CITY OF MERCER ISLAND

RE: SUB19-003, CAO19-005, SEP19-009 Lady Bug Trust **Request for Information #2**
Consolidated Land Use Applications for a subdivision of one lot into two lots, extinguish and create new easements, and steep slope alteration located within the shorelands.

SHEET NO.
4

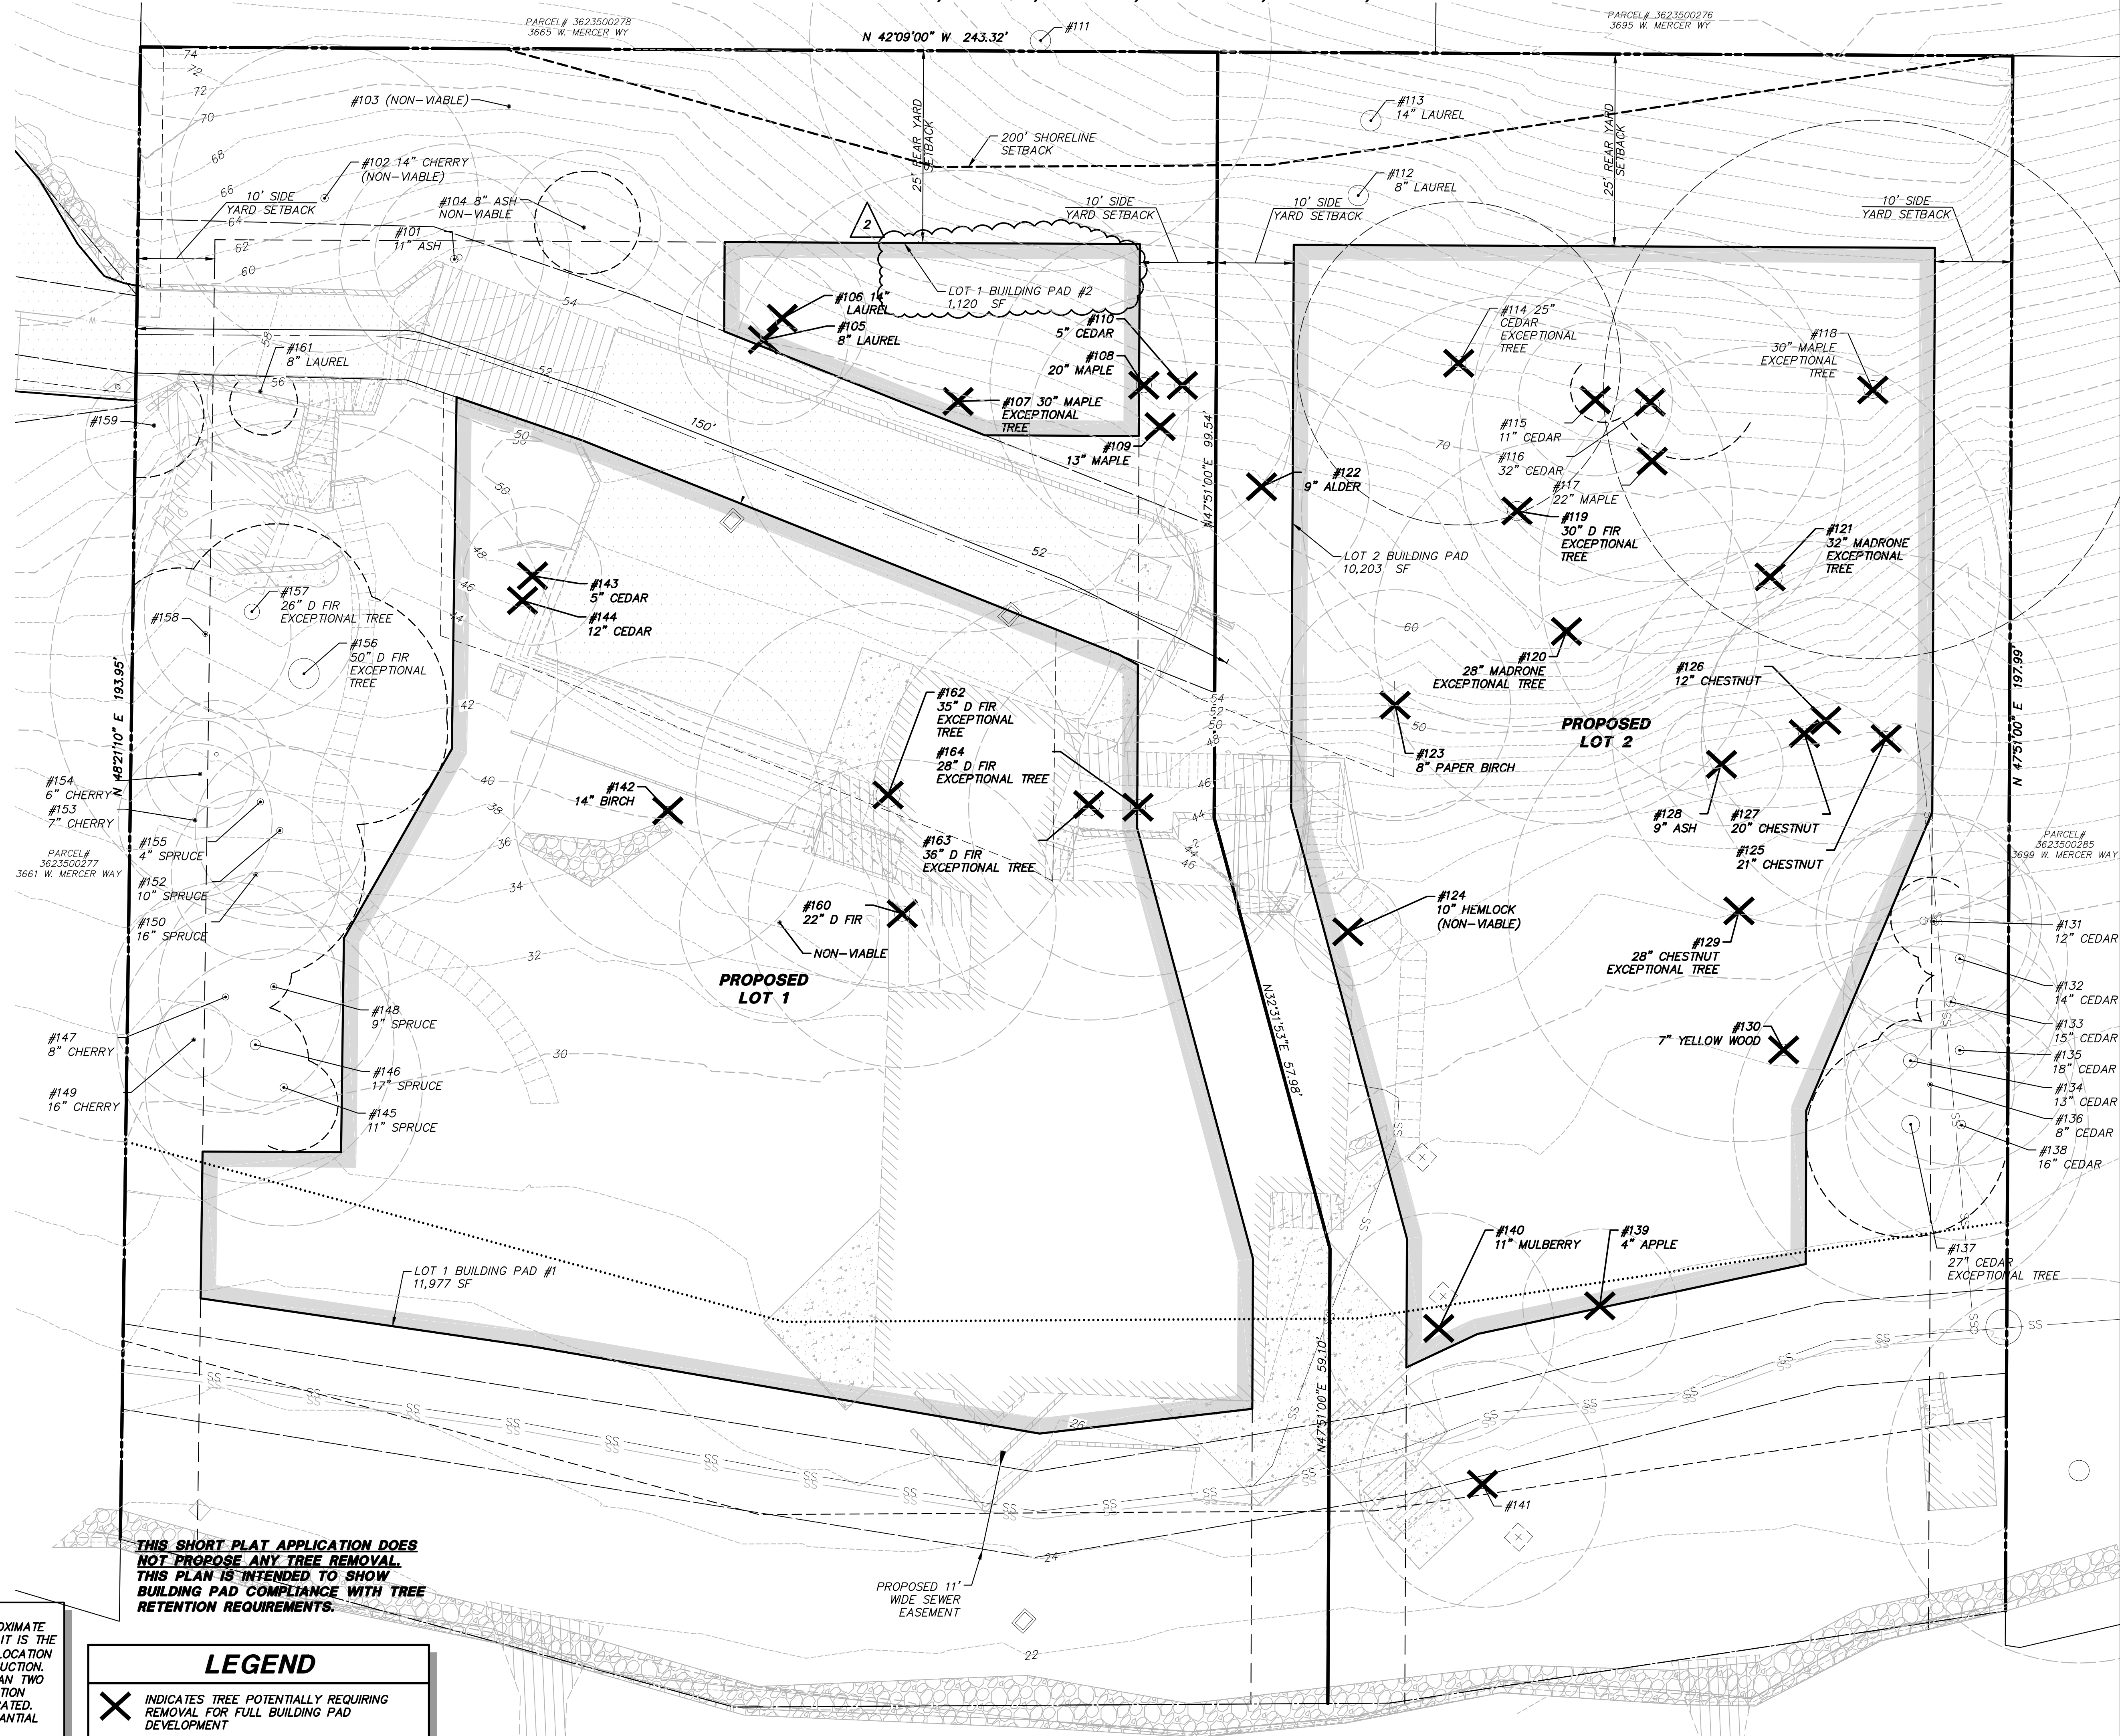
5. Repeat correction and clarification. The property is just one lot and the tree inventory worksheet shall be calculated for this one lot. Not two calculations for the proposed lot.
6. Provide Tree Inventory Worksheet showing retainage of at least the minimum required number of trees and Exceptional Trees. This calculation should be done for the current existing lot:
<http://www.mercergov.org/files/TreeInventoryReplacementSubmittalInformation.pdf>.
7. Include a conceptual replanting plan to mitigate for all removed trees on the preliminary plat. This will avoid any bonding requirements. Including the replanting plan during the preliminary plat phase will help ensure that there is enough area for the replanting and the proposed building pad area.
